Ribble Valley Borough Council
Housing & Development Control

Planning Application No: 3/2021/1166

Proposal: Proposed single storey side and rear extension and garage conversion to form additional living accommodation.

Location: 5 Higherfield Langho BB6 8HQ

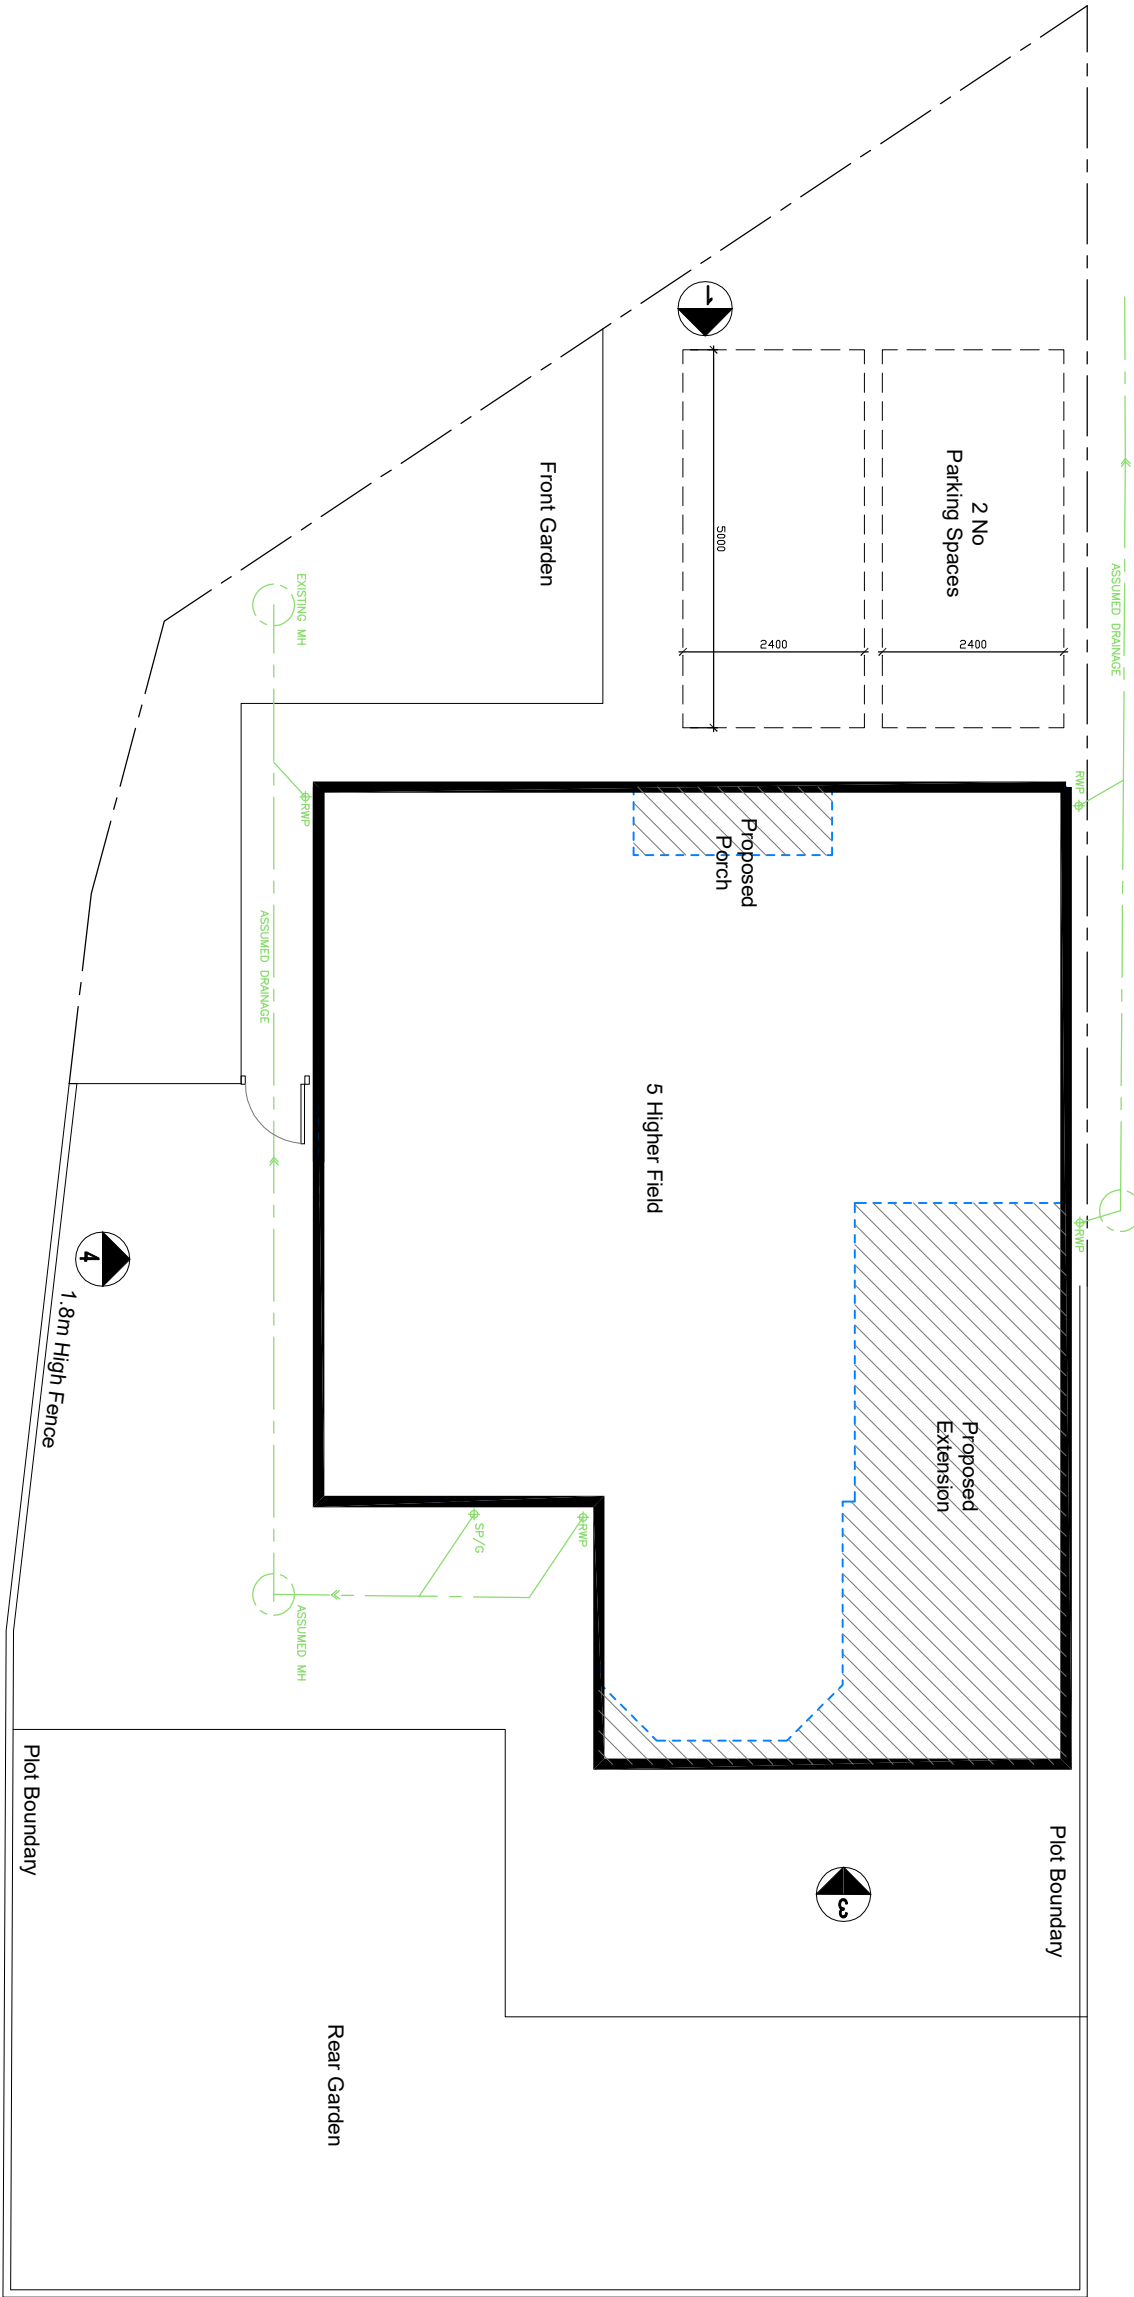
- The parking areas must be constructed of a bound porous material and created before first occupation up until the life time of the dwelling existing in its proposed state. Reason: to ensure that satisfactory parking is provided before the dwelling hereby permitted becomes operative.
